CITY OF ALBUQUERQUE

August 16, 2018

RE: McDonald's – 5324 4th Street NW
Grading Plan
Engineer Stamp Date: No Date
Hydrology File: L18D053

DRAINAGE  
AREA MAP

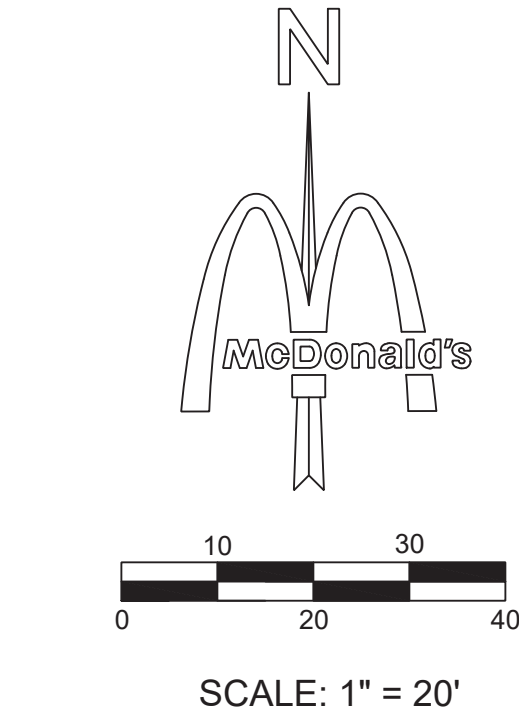
7. Please provide drainage calculations. Use the procedure for 40 acre and smaller basins as outlined in Chapter 22, Part A of the Development Process Manual (DPM). Please provide both the existing conditions and proposed conditions for the 100 year-6 hour storm event.

| DESIGNED | DATE | BY |
|--------------|---------|-----|
| GRADING PLAN | | |

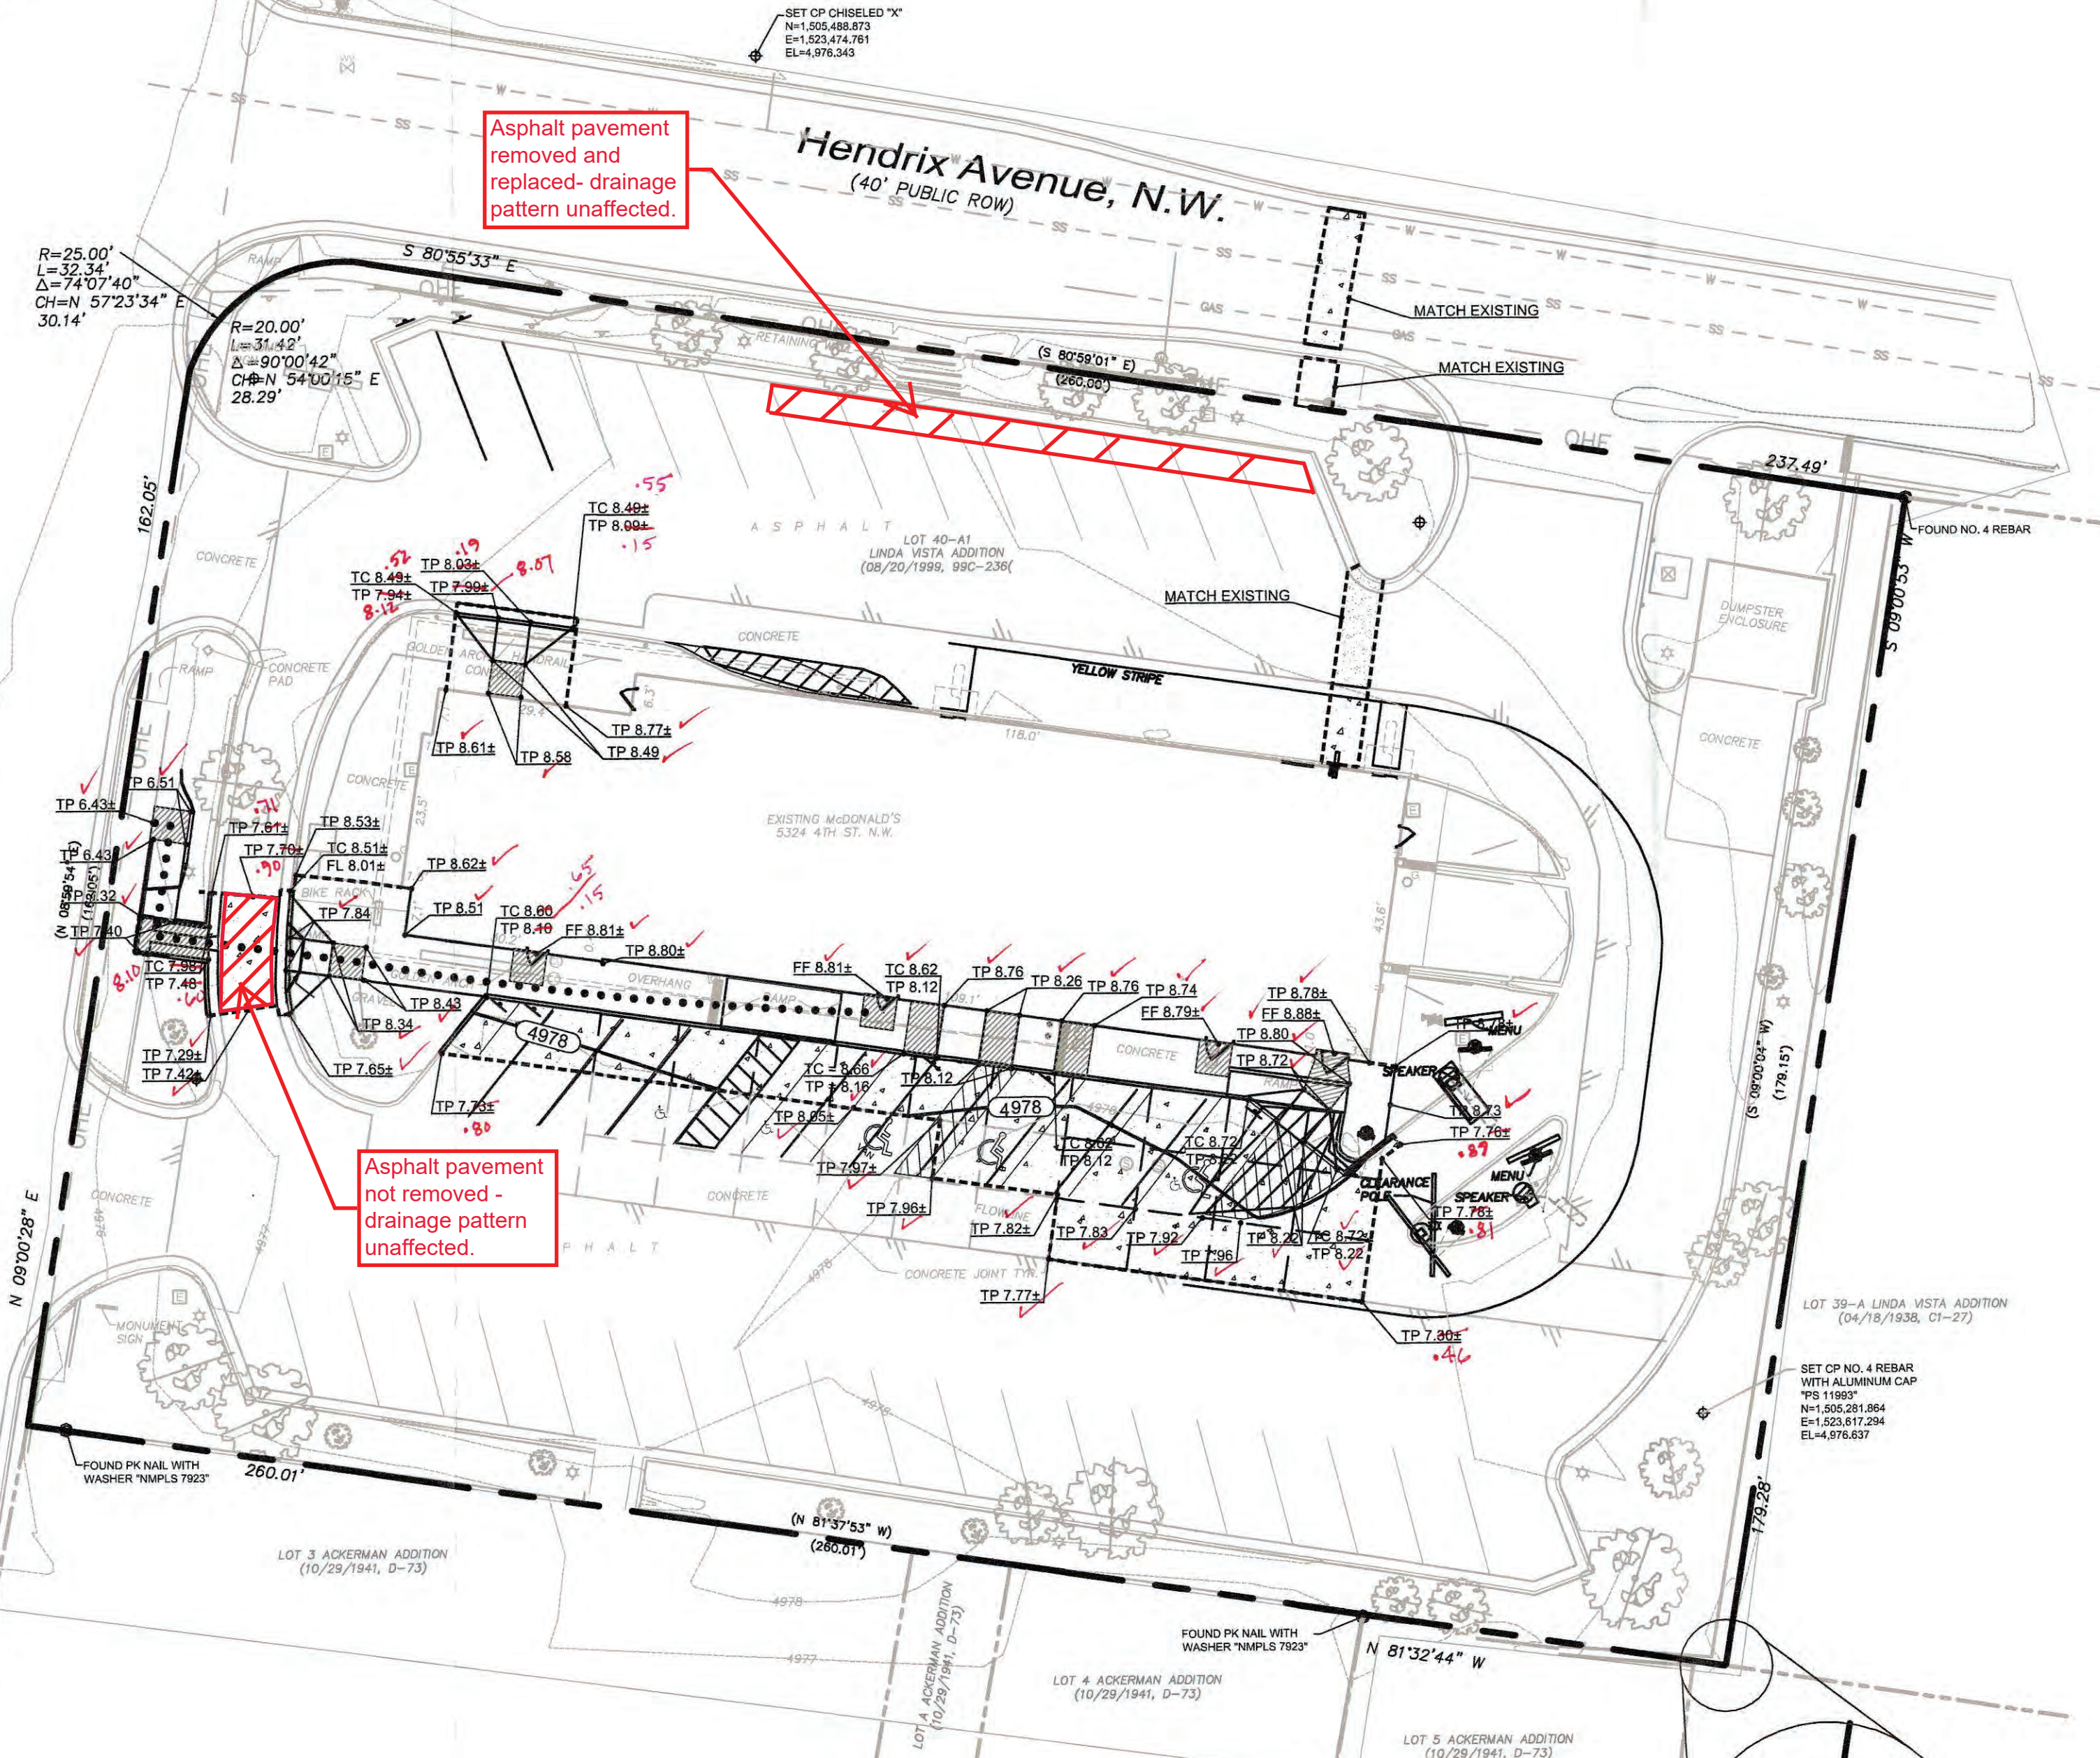
8. Please provide a paragraph stating the Existing Conditions and one stating the Proposed Conditions.
9. Please remove “Not for Construction” note.
10. Please remove the 15.5 dimension at the rear of the property.
11. Please remove the “Standard Accessibility Requirements” notes.
